MEMORANDUM

TO: Nell Donaldson, Planner
FROM: David Senus, P.E.
DATE: February 19, 2015
RE: Brighton Ave Hotel Redevelopment, Level III Site Plan Application

Woodard & Curran has reviewed the Level III Site Plan Application and Response to Comments letter for the proposed hotel redevelopment project located at 1210 Brighton Avenue in Portland, Maine. The project involves the demolition of an existing 135 room motel and the construction of a new 86 room hotel, parking lot, and utilities.

**C4.0**

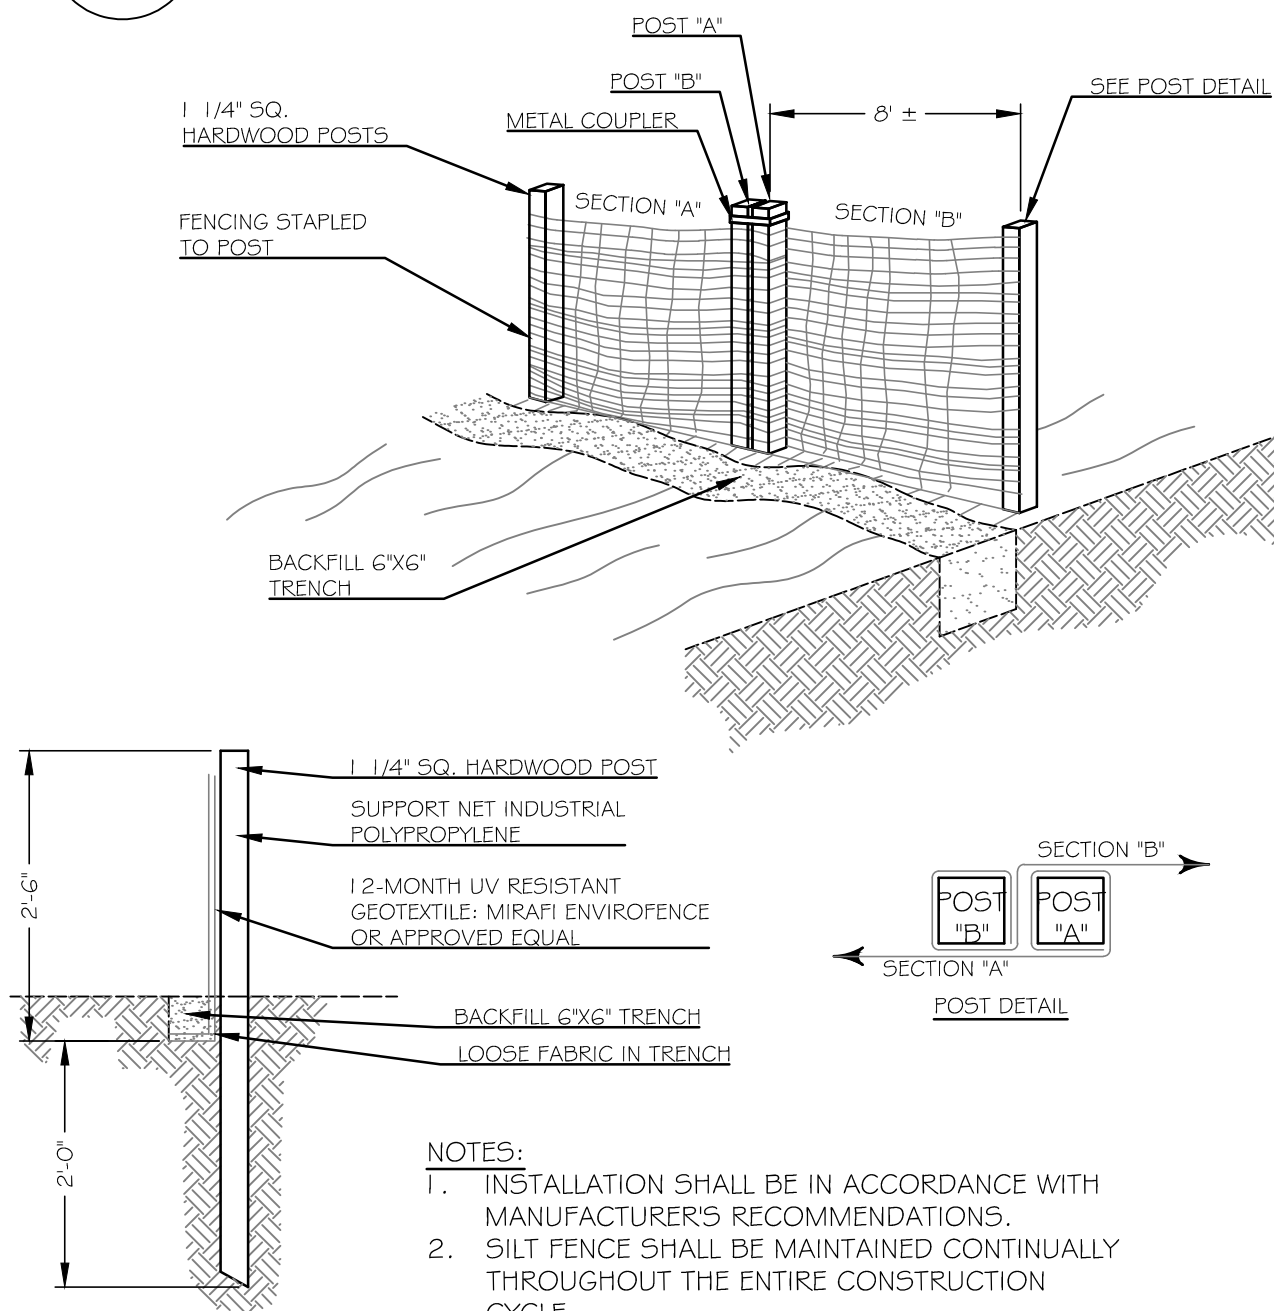
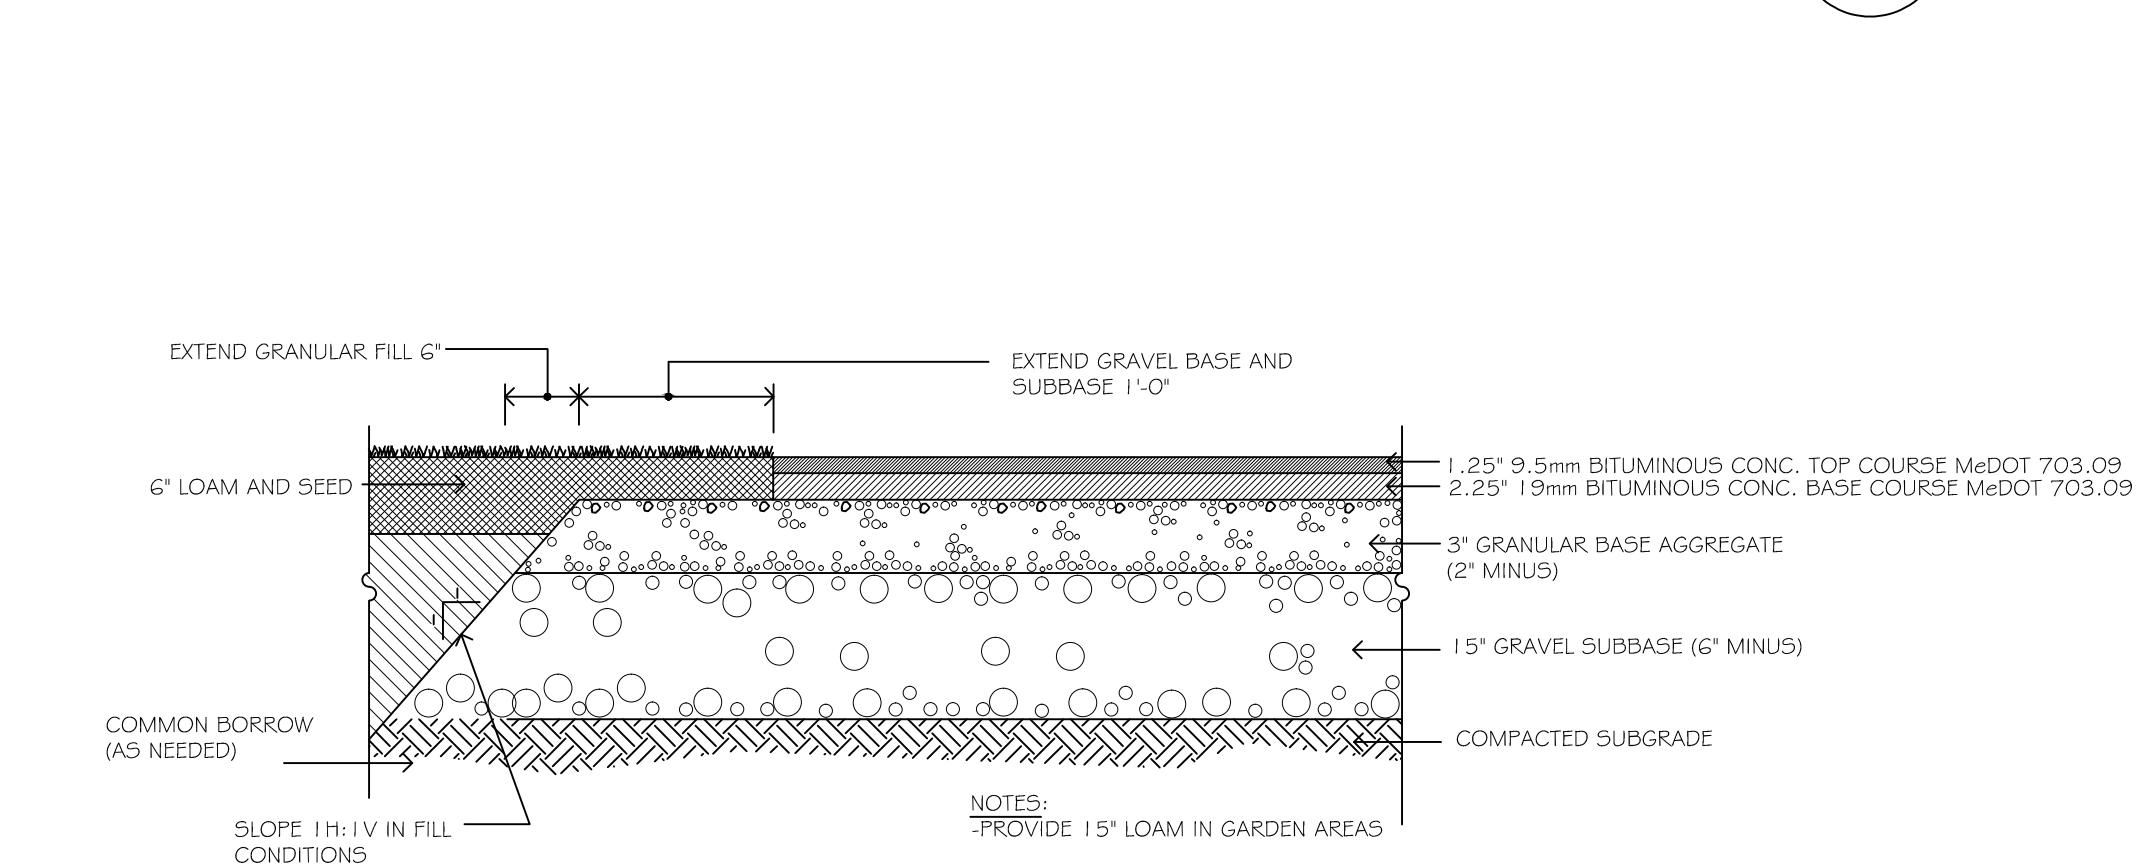
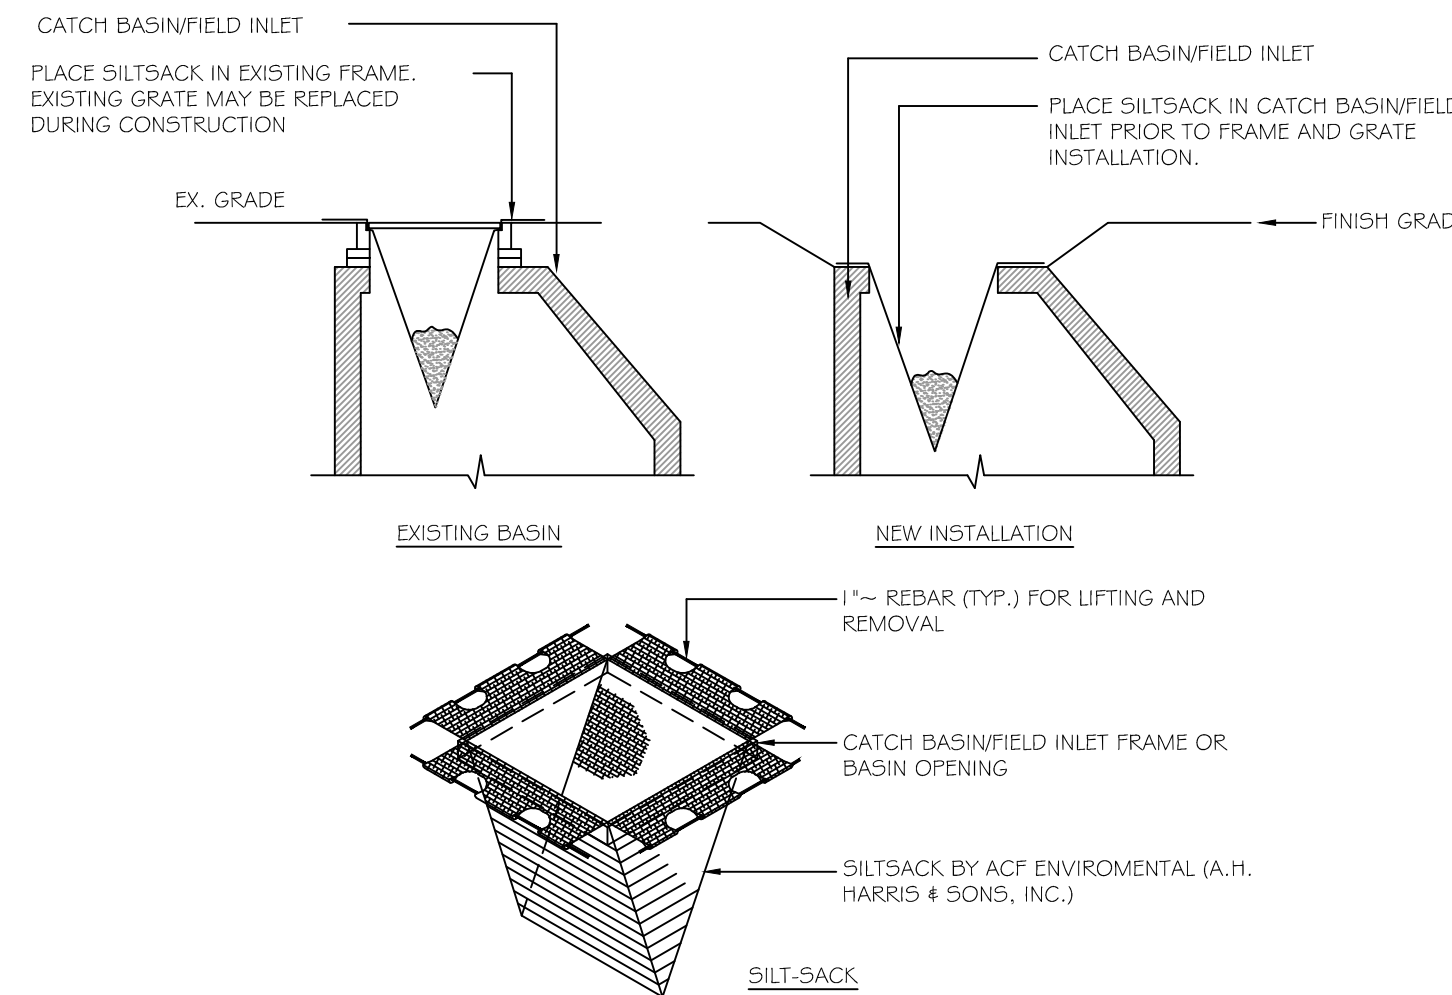
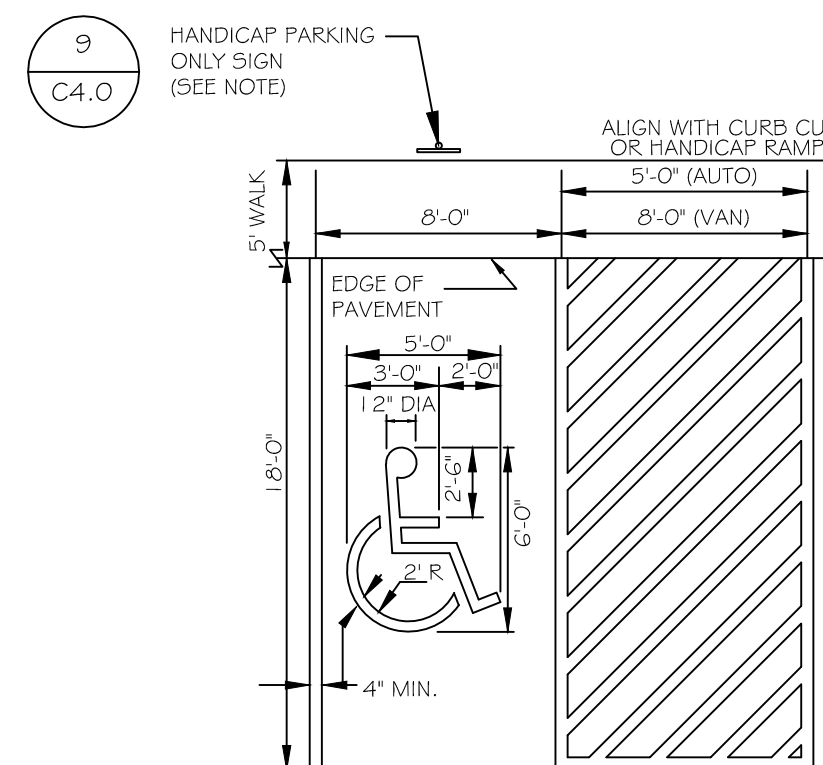
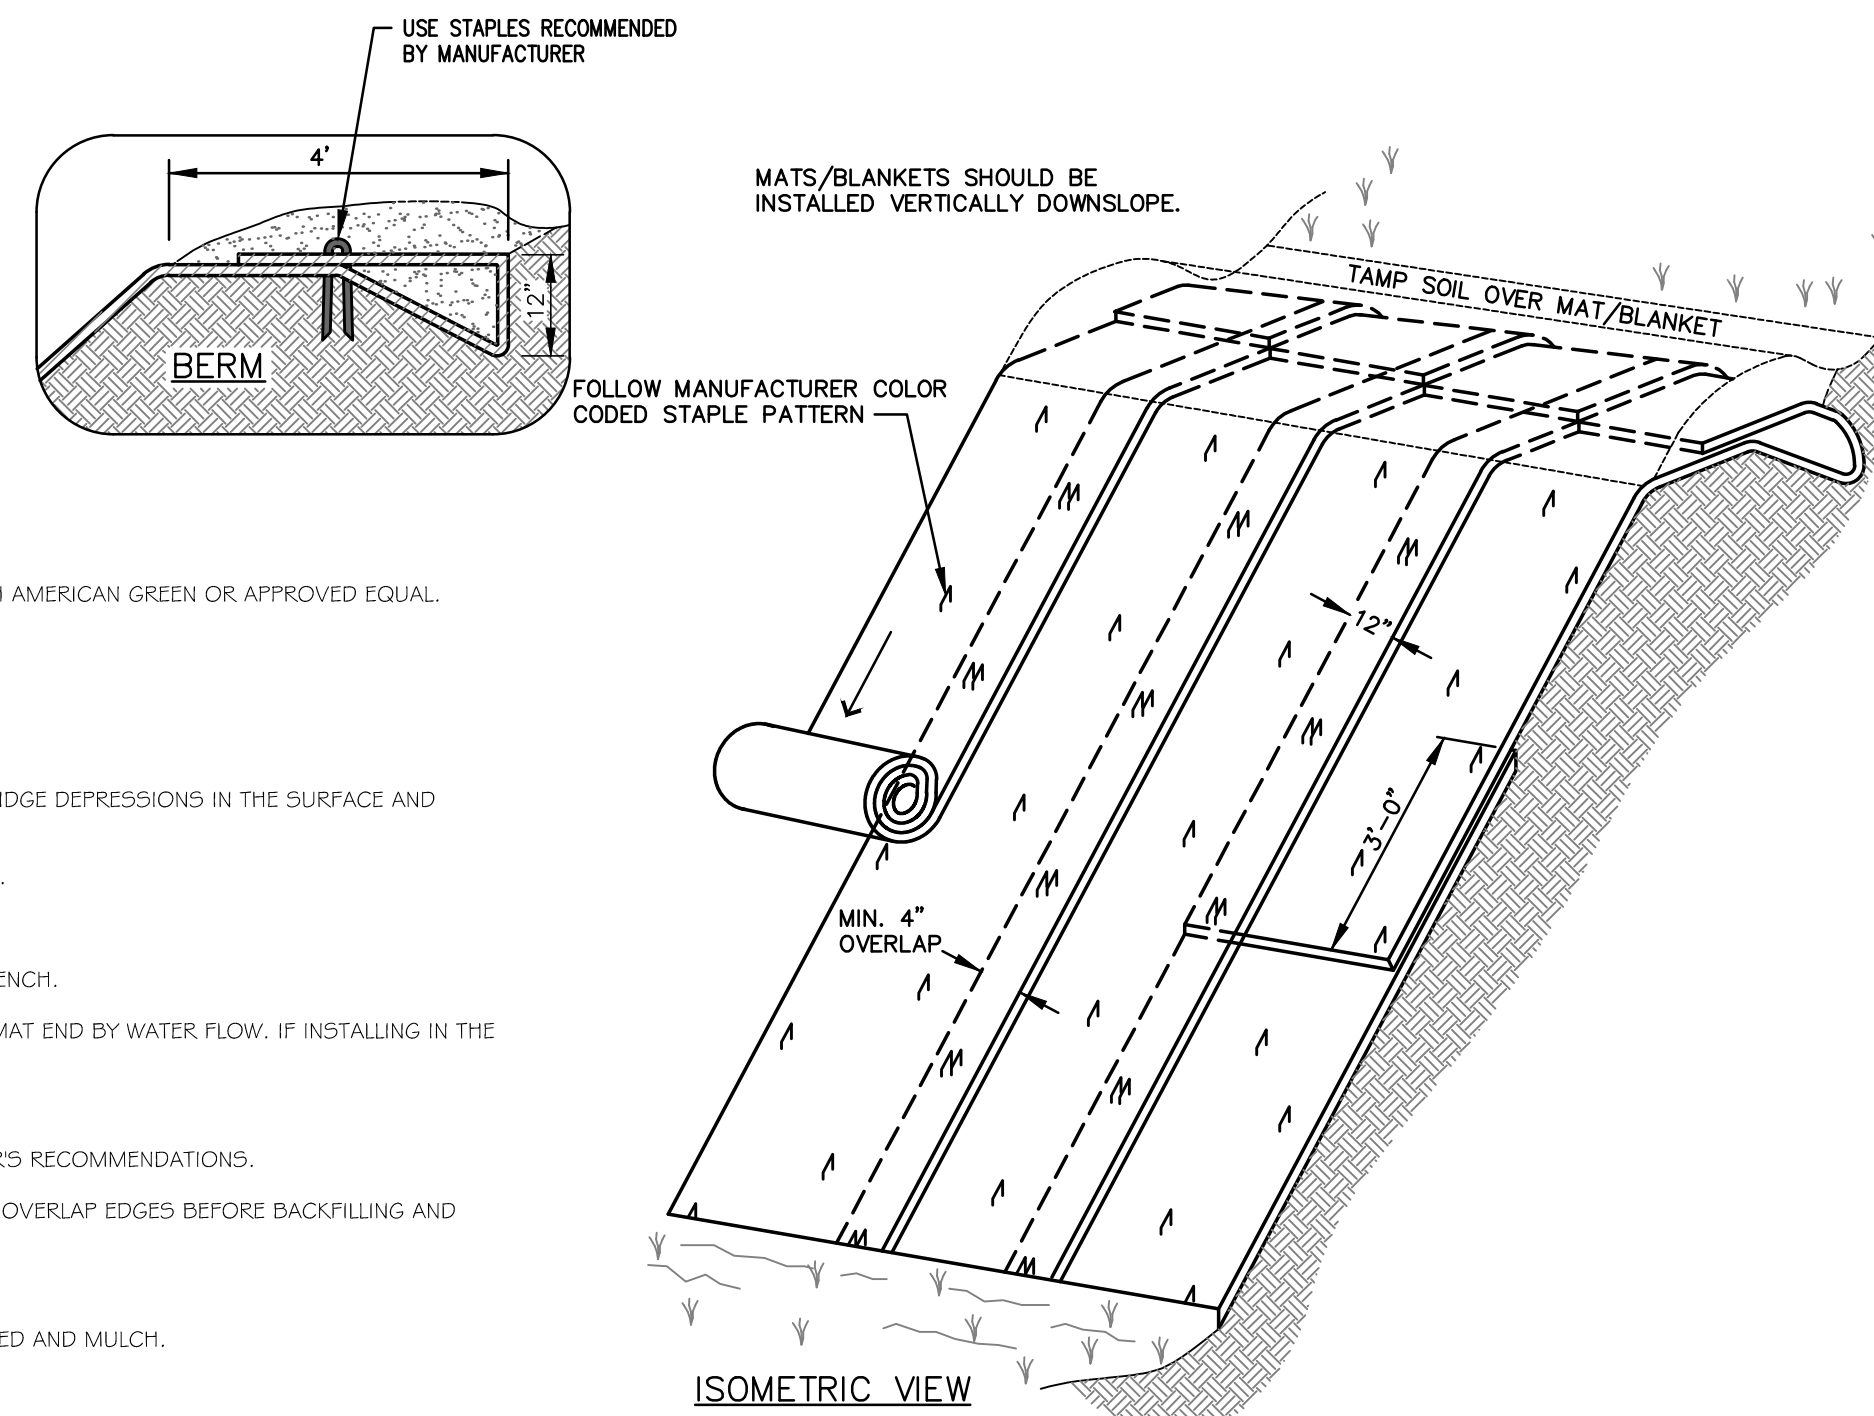
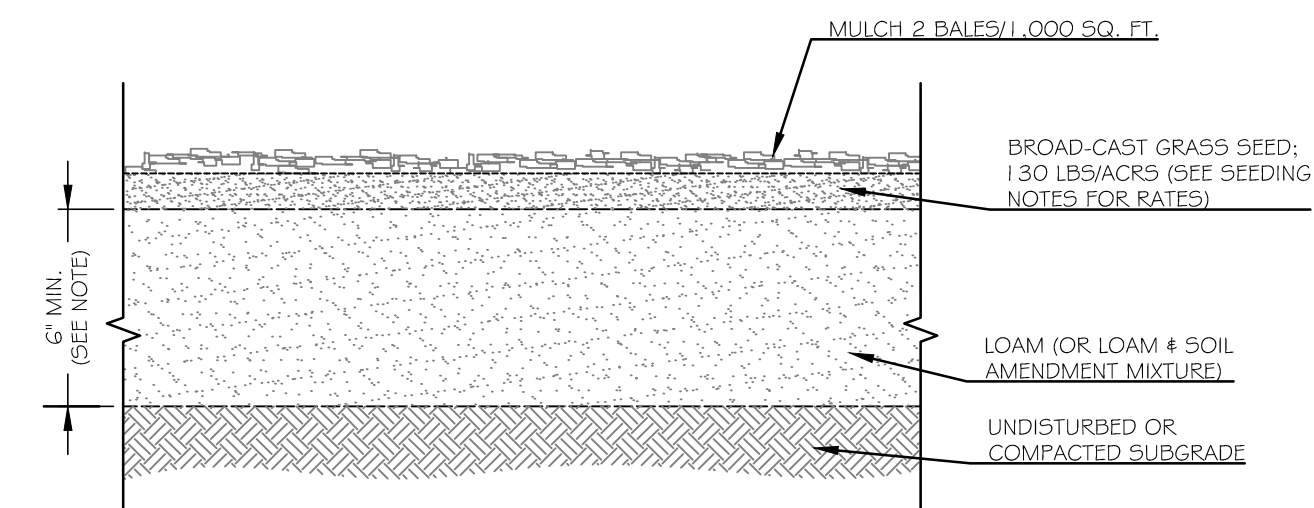
1. Basic Standards: A site plan and details have been provided to address erosion and sediment control requirements, inspection and maintenance requirements, and good housekeeping practices in general accordance with Appendix A, B, & C of MaineDEP Chapter 500; however, a written erosion and sediment control plan and/or detailed erosion and sediment control notes should be prepared and submitted for review. The Applicant states that a written erosion and sedimentation control plan will be provided with the Final Plan submission; however, a copy of this plan has not been received at this time.

1 RIP-RAP APRON (PIPE OUTLET)
C4.5 NOT TO SCALE

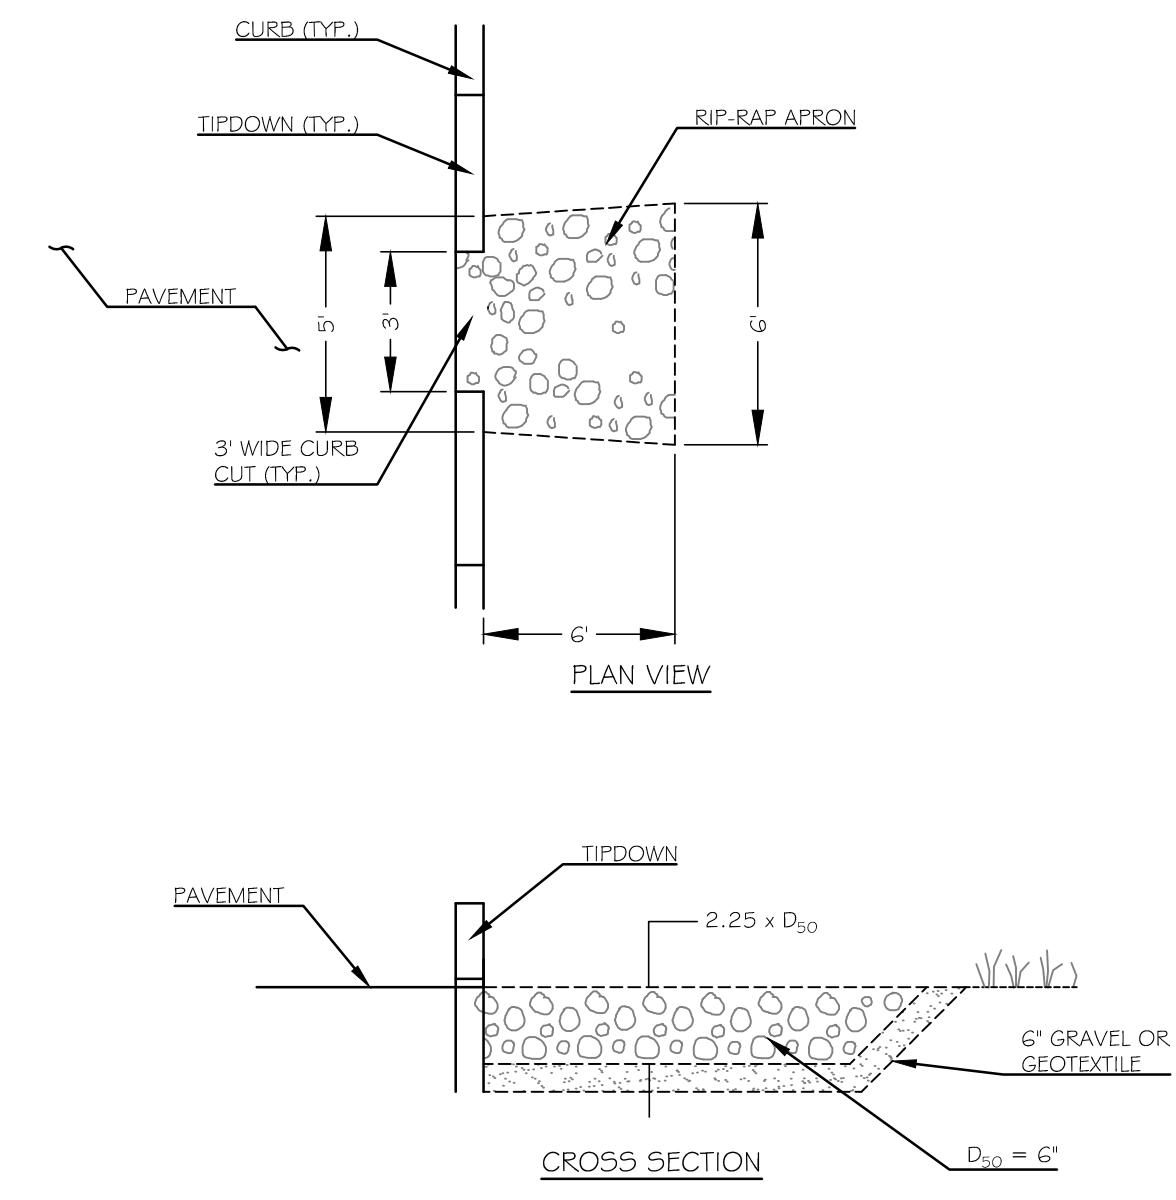
2. A stormwater outfall proposed on the southern portion of the site (AP#2 on sheet D2.0) discharges to an existing swale within a CMP easement. The Applicant proposes a riprap apron at the pipe outlet, and Walsh Engineering Associates has stated that they will review the condition of the existing pipe outlet and swale when the snow has melted to determine if additional stabilization will be required. We recommend that Site Plan approval include a condition requiring that the Applicant's engineer inspect the stormwater outfall AP#2 on Sheet D2.0 and provide a written description and photographs of this outlet, along with any additional proposed stabilization measures for review and approval by the City.
